EL PASO COUNTY GRADING AND EROSION CONTROL PLAN CHECKLIST

EPC Project Number: CDR-22-009

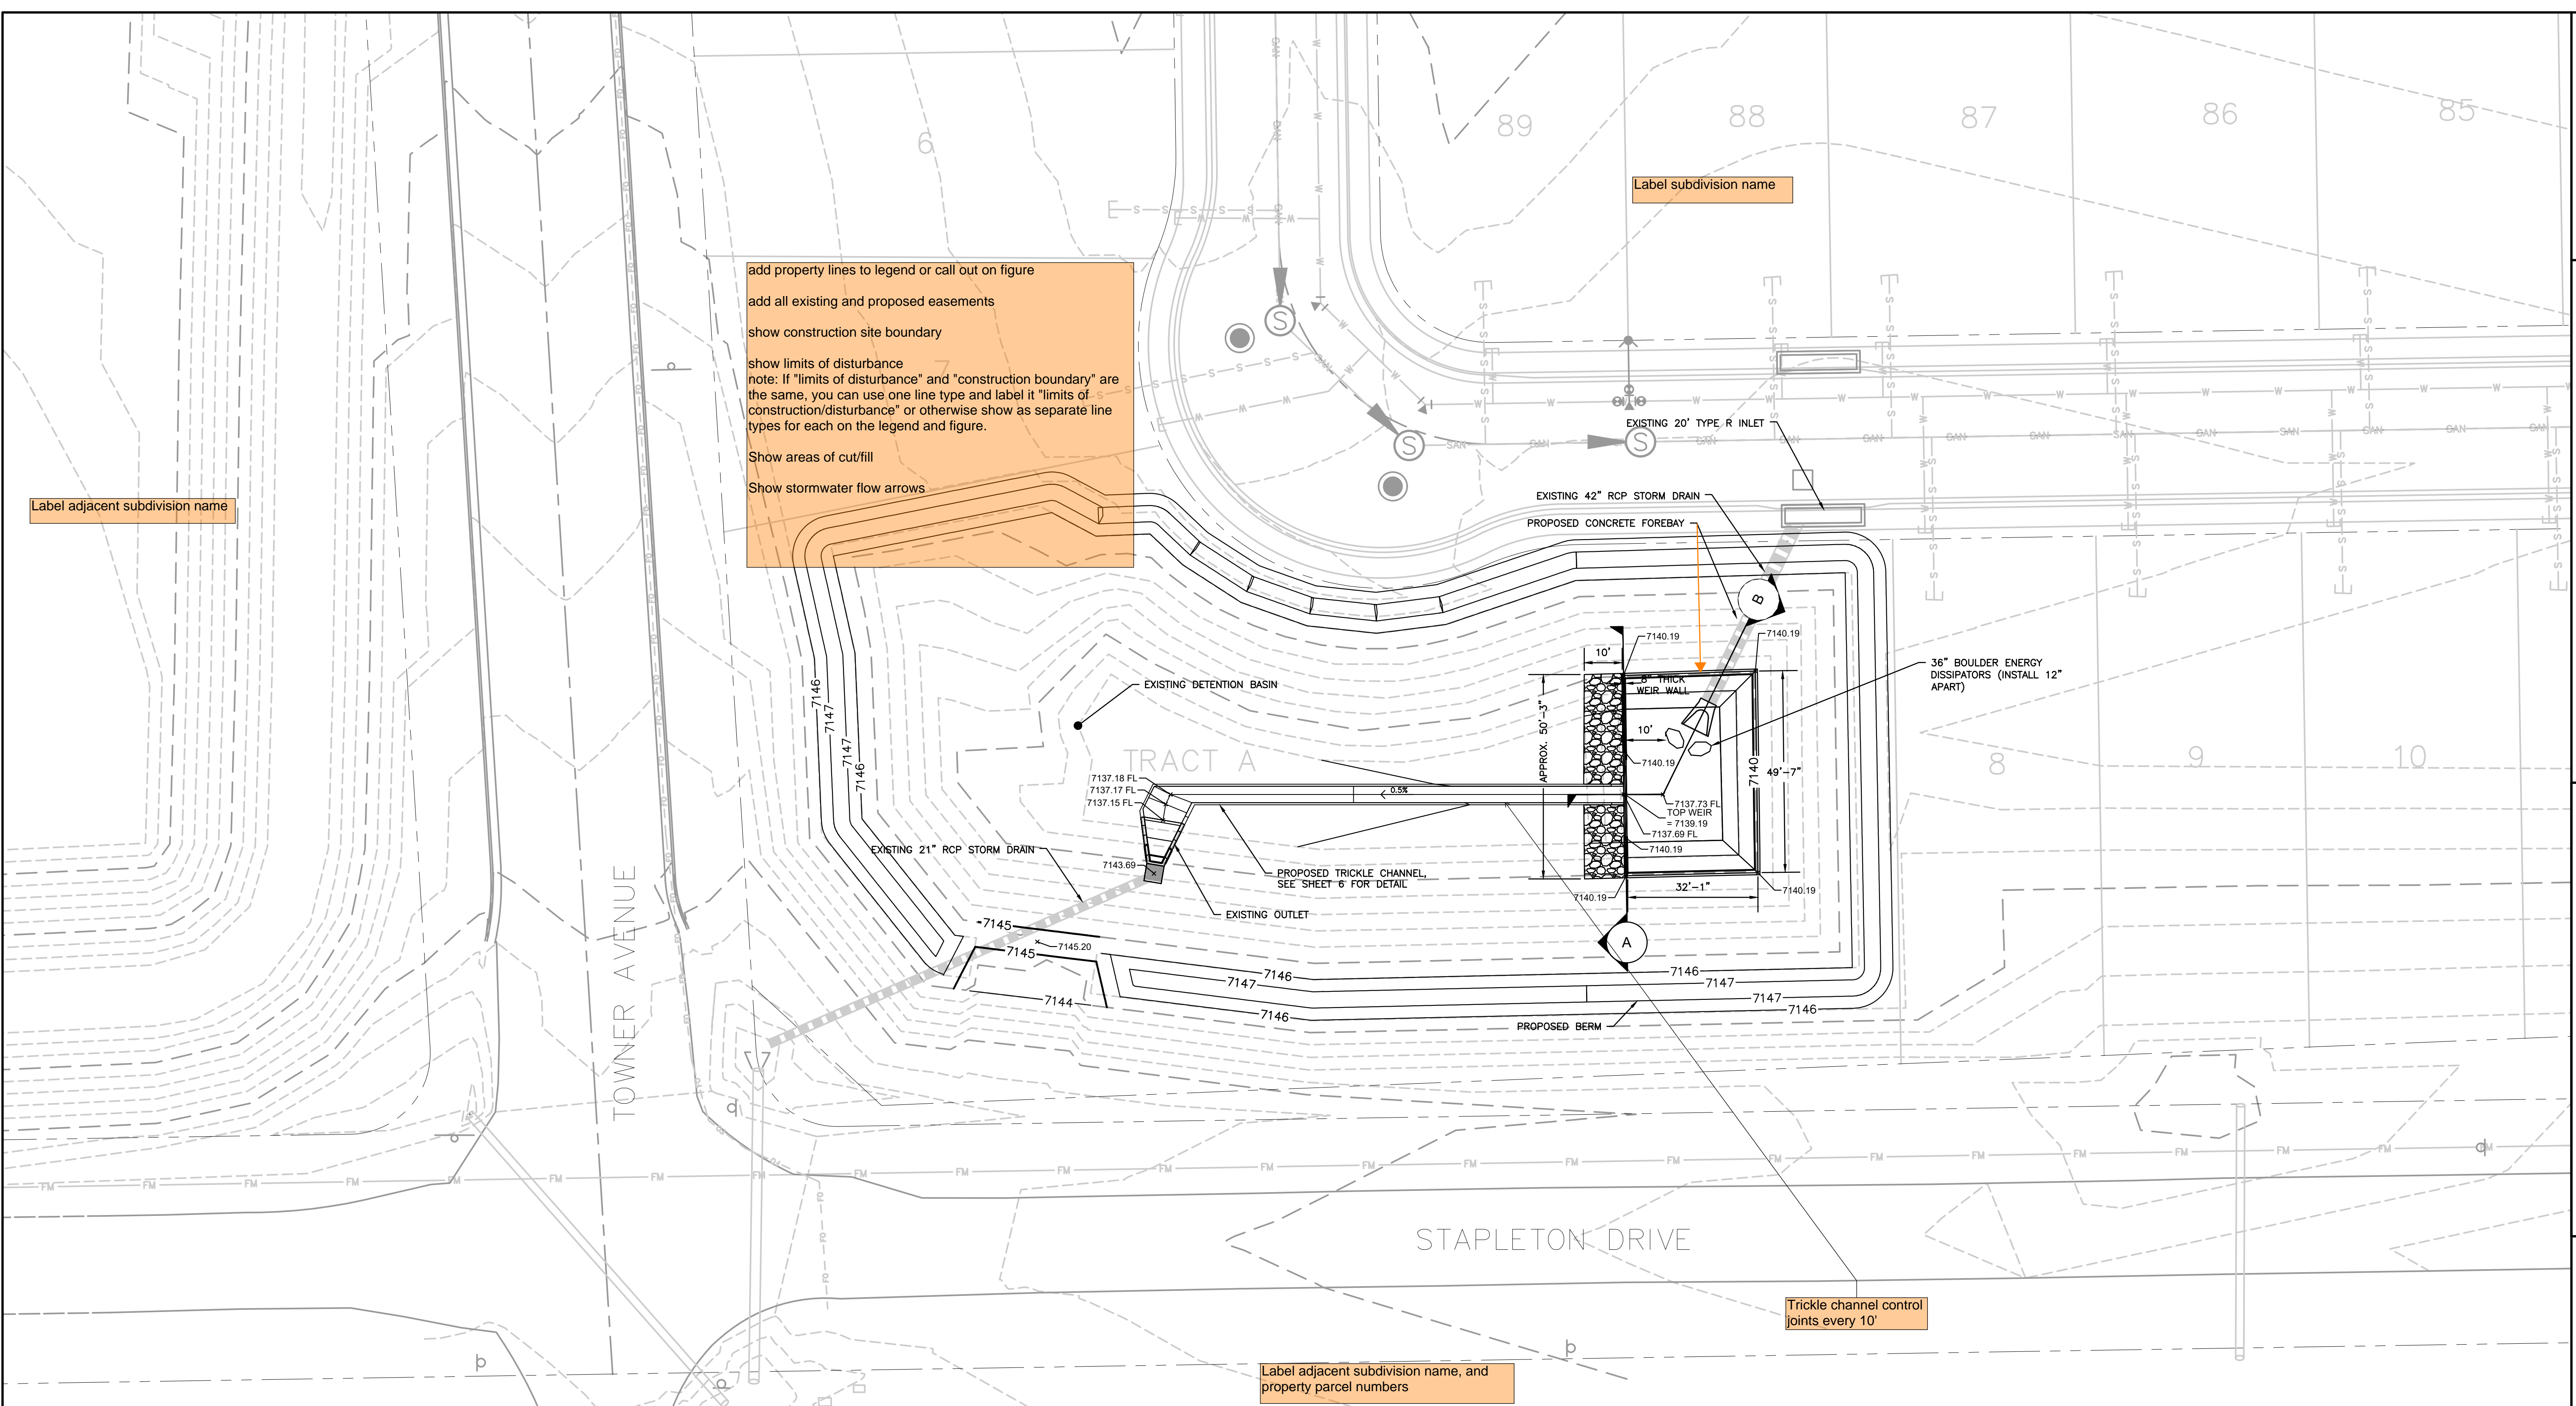
Applicant	EPC
1. GRADING AND EROSION CONTROL PLAN (complete form using Y, N, N/A in the "Applicant" column)			
a	Vicinity map	Y	✓
b	Adjacent city/town/jurisdictional boundaries, subdivision names, and property parcel numbers labeled	Y	✗
c	North arrow and acceptable scale (1"=20' to 1"=100')	Y	✓
d	Legend for all symbols used in the plan	Y	✗
e	Existing and proposed property lines. Proposed subdivision boundary for subdivision projects	Y	✓
f	All existing structures	Y	✓
g	All existing utilities	Y	✓
h	Construction site boundaries	Y	✗
i	Existing vegetation (notes are acceptable in cases where there is no notable vegetation, only grasses/weeds, or site has already been stripped)	Y	✗
j	FEMA 100-yr floodplain	Y	N/A
k	Existing and proposed water courses including springs, streams, wetlands, detention ponds, stormwater quality structures, roadside ditches, irrigation ditches and other water surfaces. Show maintenance of pre-existing vegetation within 50 feet of a receiving water	Y	✓

l	Existing and proposed contours 2 feet or less (except for hillside)	Y	✓
m	Limits of disturbance delineating all anticipated areas of soil disturbance	Y	✗
n	Identify and protect areas outside of the construction site boundary with existing fencing, construction fencing or other methods as appropriate	Y	✓
o	Off-site grading clearly shown and called out	Y	N/A
p	Areas of cut and fill identified	Y	✗
q	Conclusions from soils/geotechnical report and geologic hazards report incorporated in grading design (slopes, embankments, materials, mitigation, etc.)	Y	N/A
r	Proposed slopes steeper than 3:1 with top and toe of slope delineated. Erosion control blanketing or other protective covering required	Y	✓
s	Stormwater flow direction arrows	Y	✗
t	Location of any dedicated asphalt / concrete batch plants	Y	N/A
u	Areas used for staging, storage of building materials, soils (stockpiles) or wastes. The use of construction office trailers requires PCD permitting	Y	N/A

v	All proposed temporary construction control measures, structural and non-structural. Temporary construction control measures shall be identified by phase of implementation to include "initial," "interim," and "final" or shown on separate phased maps identifying each phase	Y	✗
w	Vehicle tracking provided at all construction entrances/exits. Construction fencing, barricades, and/or signage provided at access points not to be used for construction	Y	✓
x	Temporary sediment ponds provided for disturbed drainage areas greater than 1 acre	Y	N/A
